OUTLOOK POWERS & GRINNELL

DEVELOPMENT PLAN

EL PASO COUNTY, COLORADO
SITE DEVELOPMENT PLAN

V1_Site Development Plan Redlines.pdf Markup Summary

OUTLOOK POWERS & GRINNELL

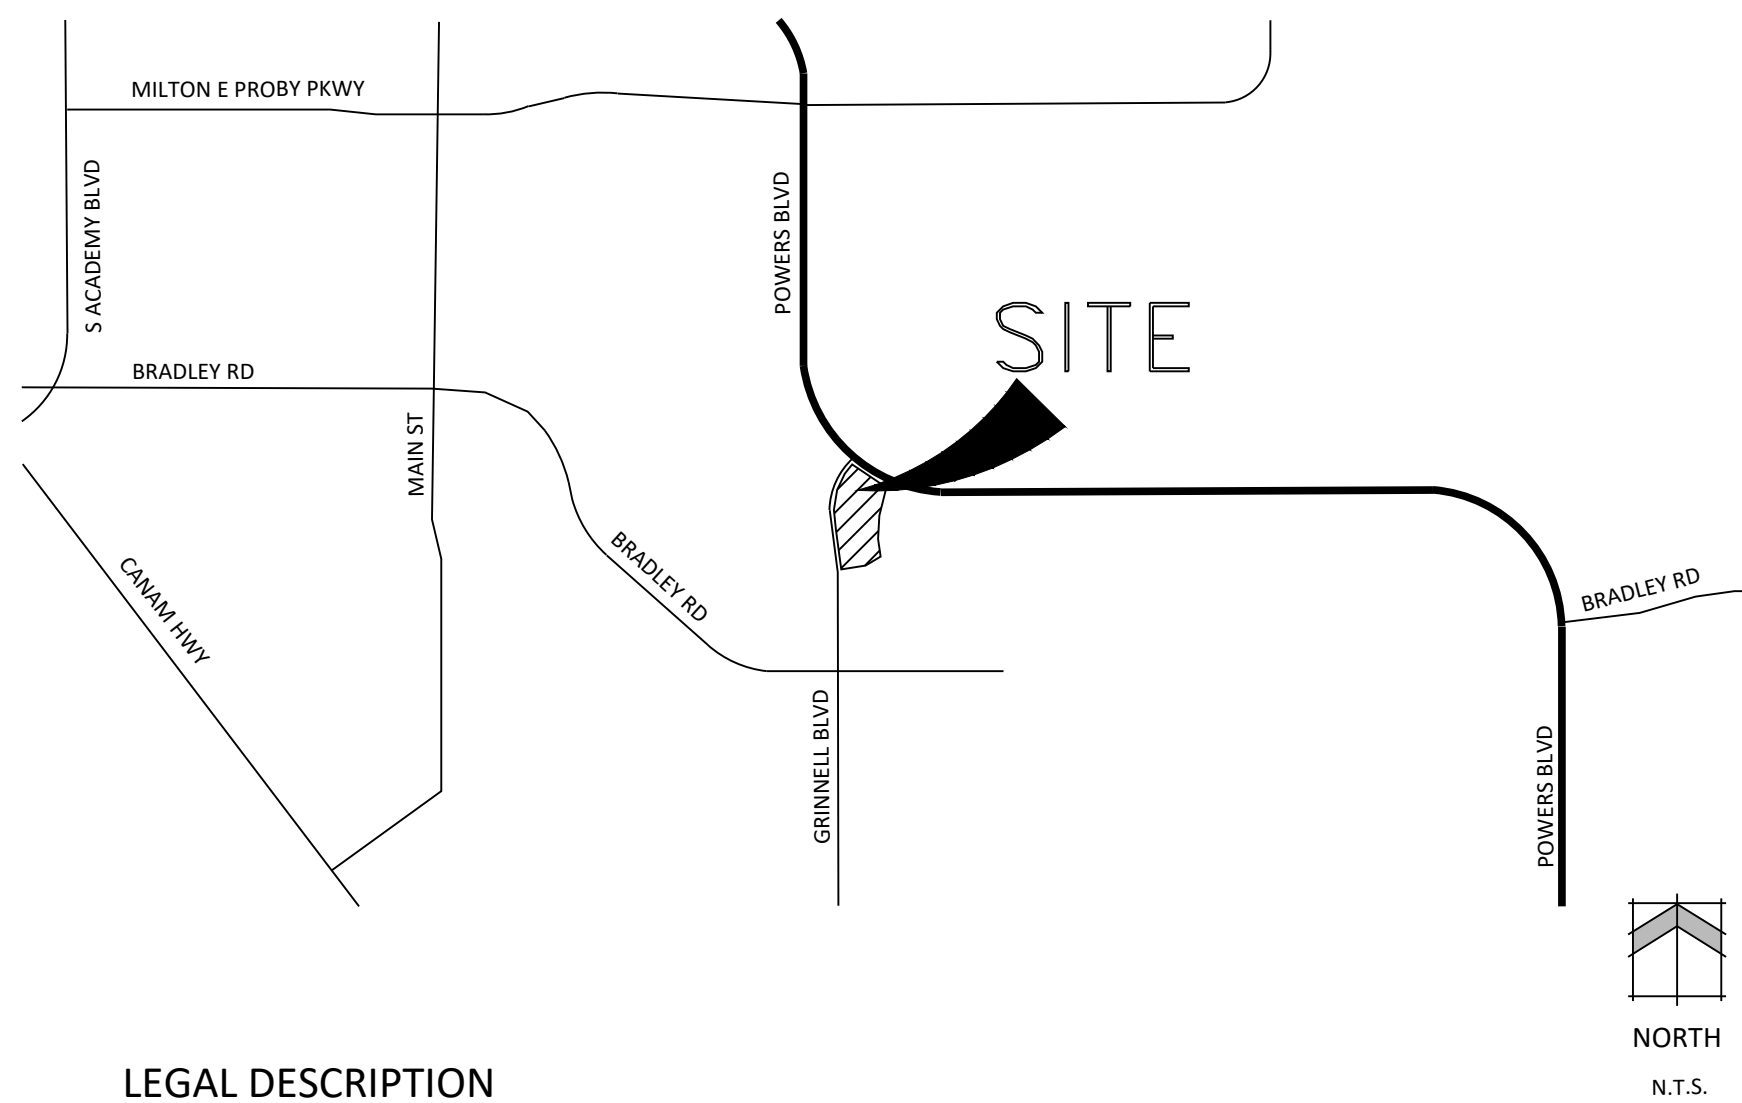
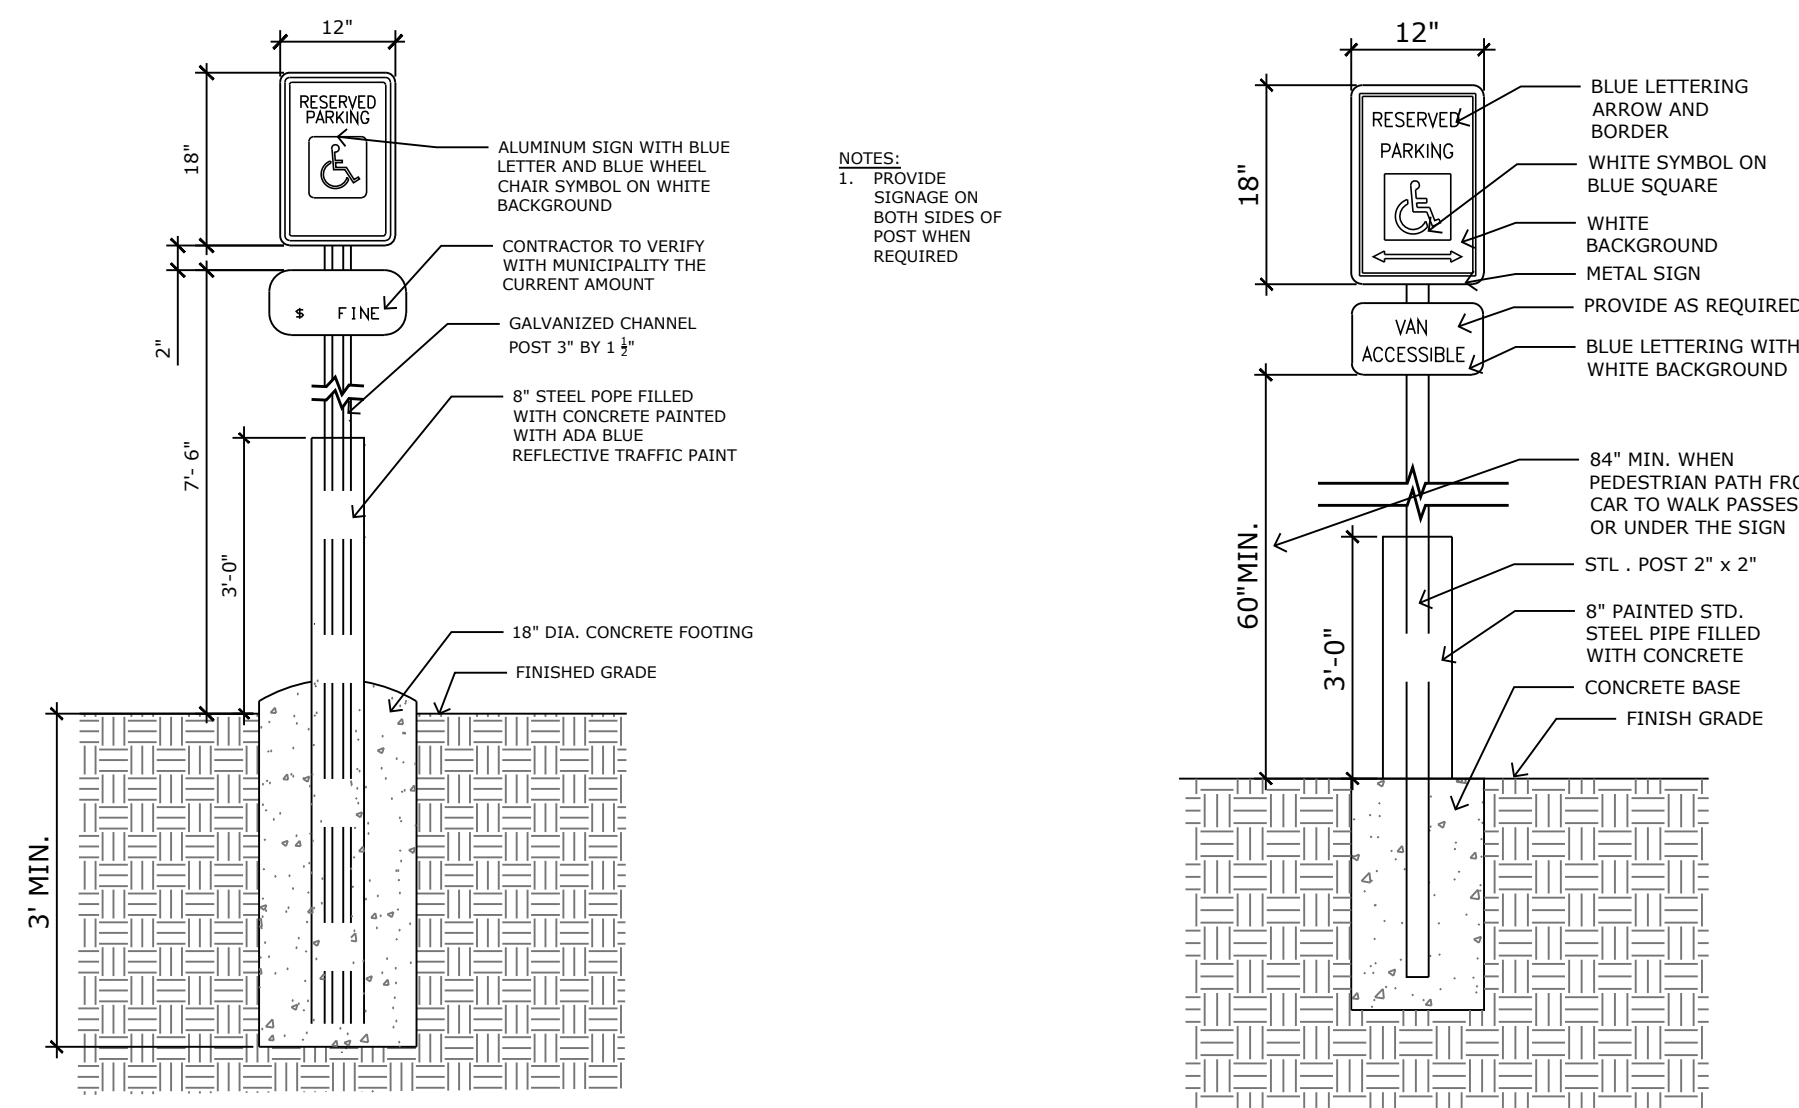
Identify proposed sidewalks. Verify concrete thickness with construction drawings.

Add a note stating all retaining walls greater than 4 feet require a building permit from the Pikes Peak Regional Building Department.

Revise sheet index and count to include only the sheets submitted in the site development plan set.

Add *PCD File No. PPR2320*

SITE DEVELOPMENT PLAN

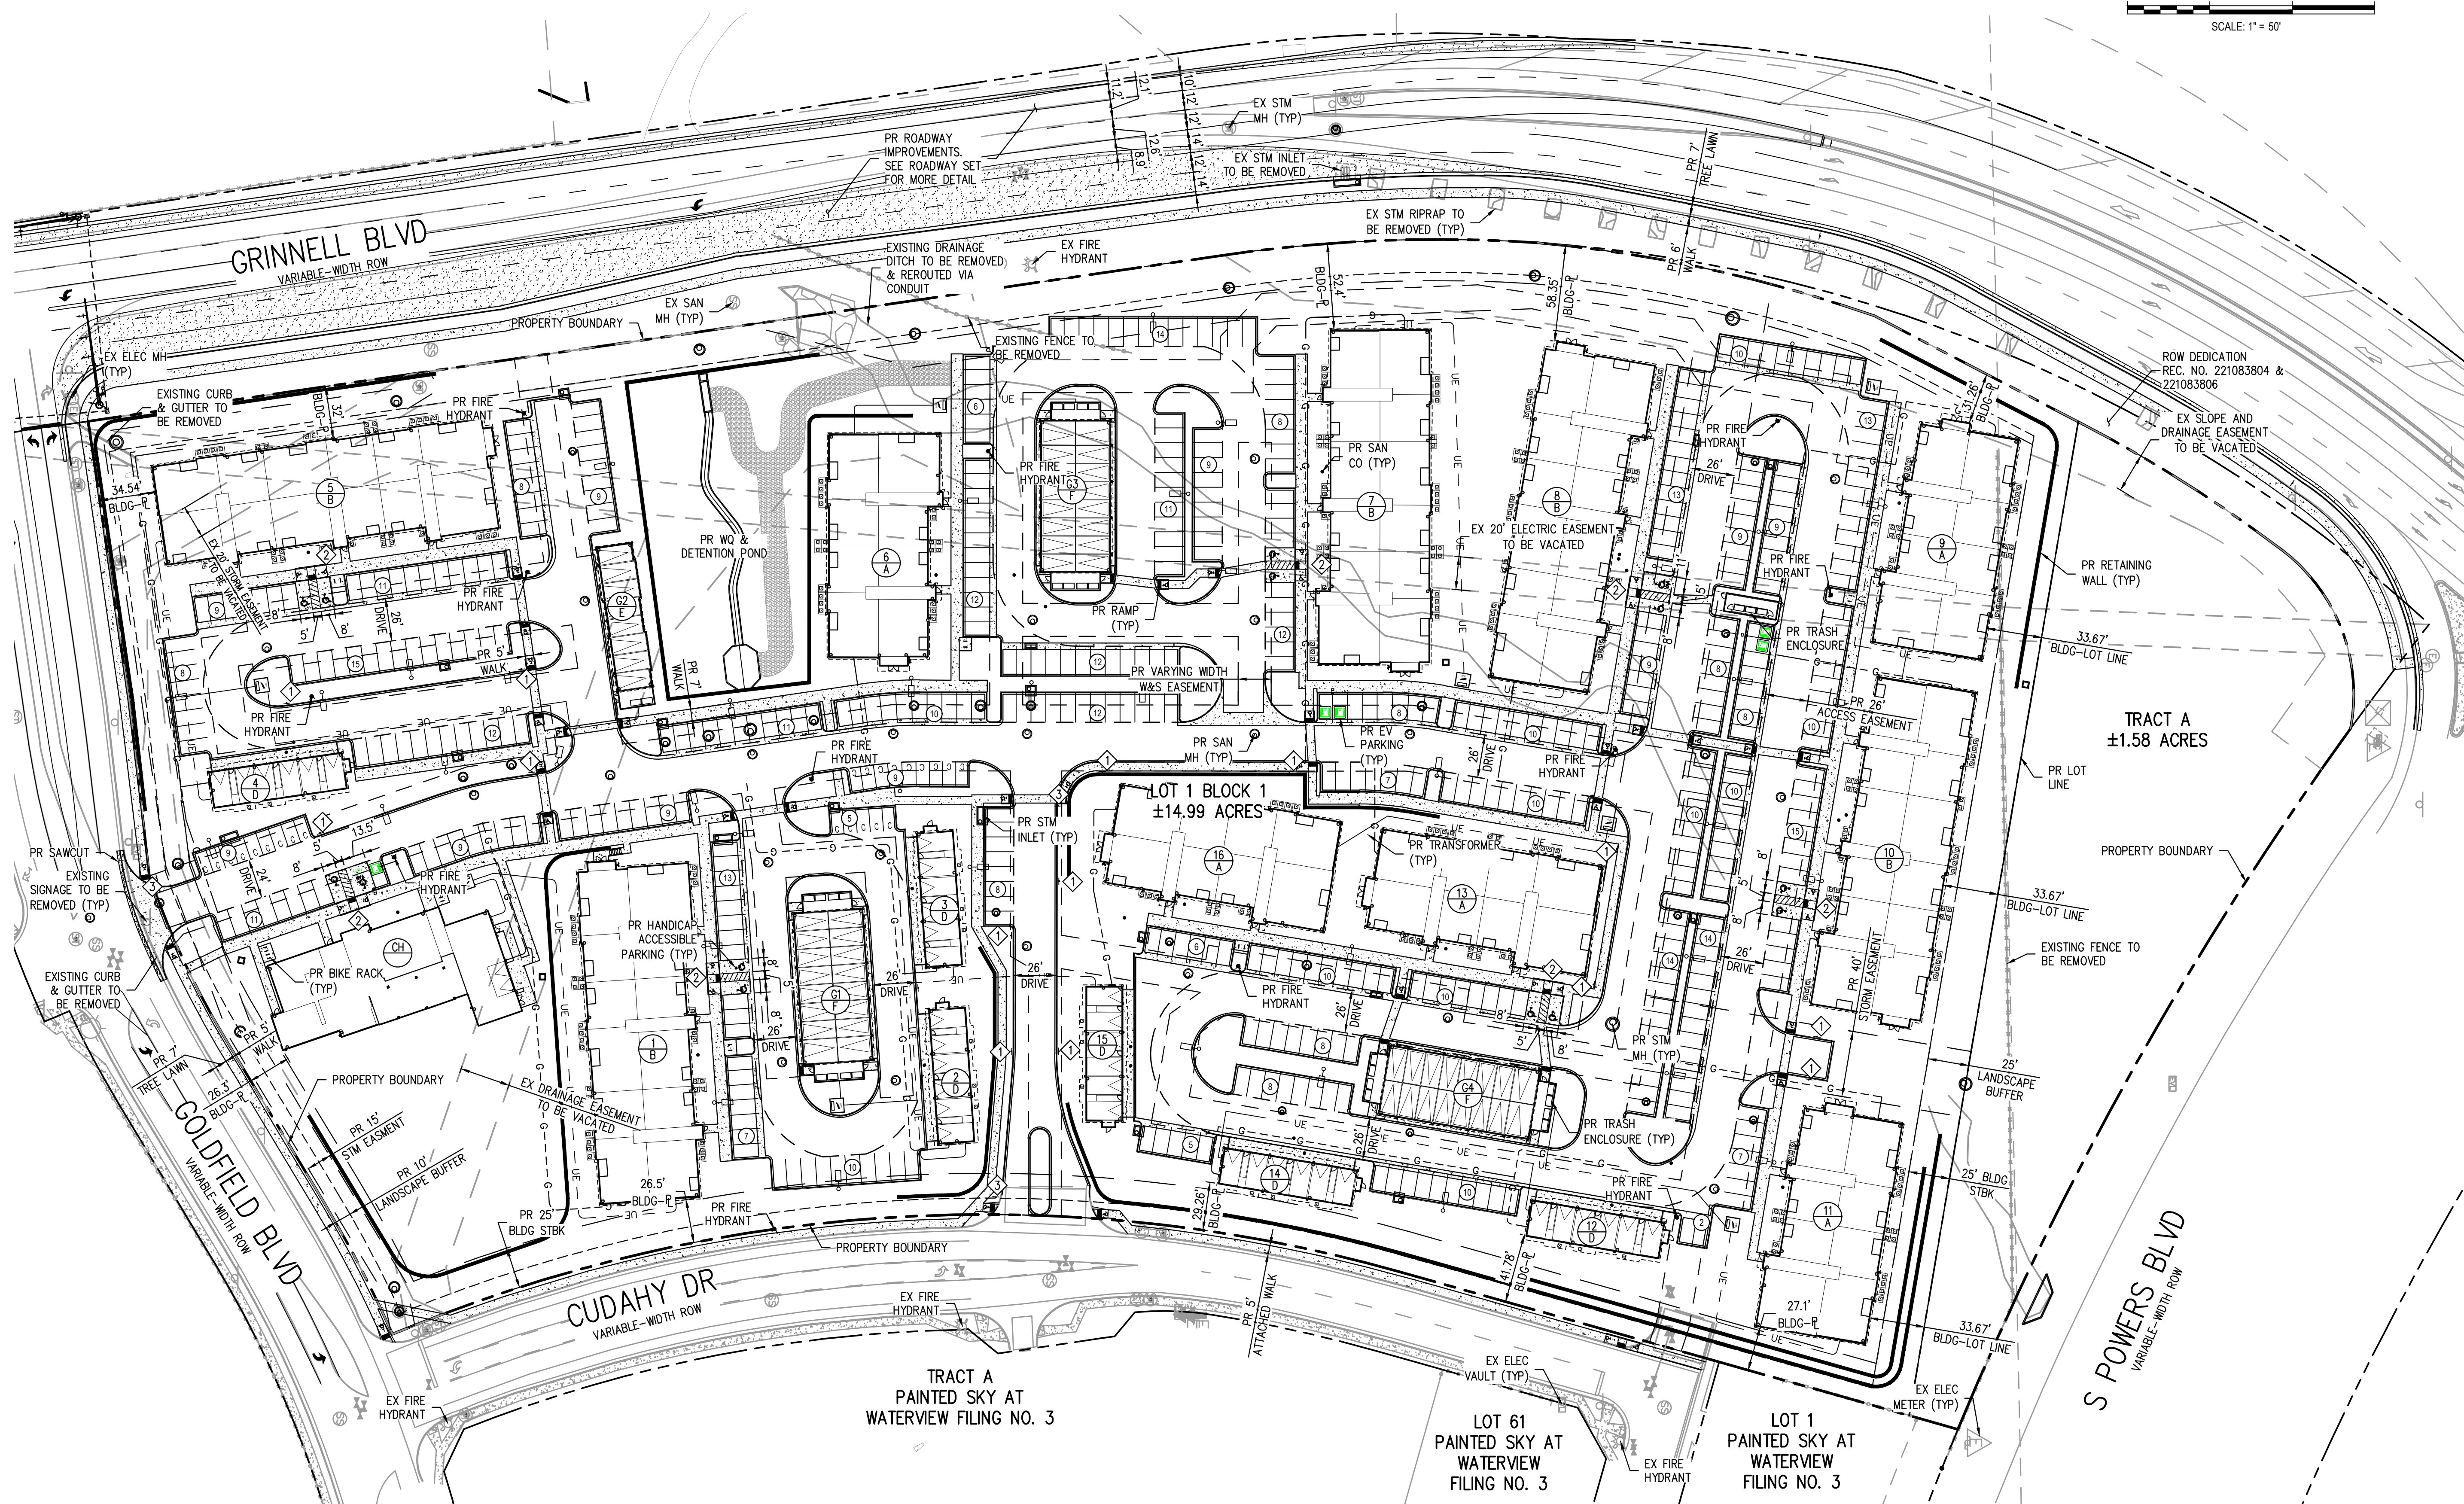
You need to provide a legend on each page of the Site development plan. That needs to include all of the symbology depicted in the images provided with this application.

Refer to comments on the construction drawings in SF2318. Update site development plan to reflect revisions and comments shown on the CD set.

Show and label right-of-way lines

Where is the location of the new signage "Property Name"?

Provide a legend for all symbols and linetypes

Please label all drainage and utility infrastructure

Show public improvement easement for all similar locations

Refer to comment on CD set. Median will have to be revised as it is blocking pedestrian access route.

Refer to comments on the CD set in SF2318. Pedestrian ramp will be required to be removed.
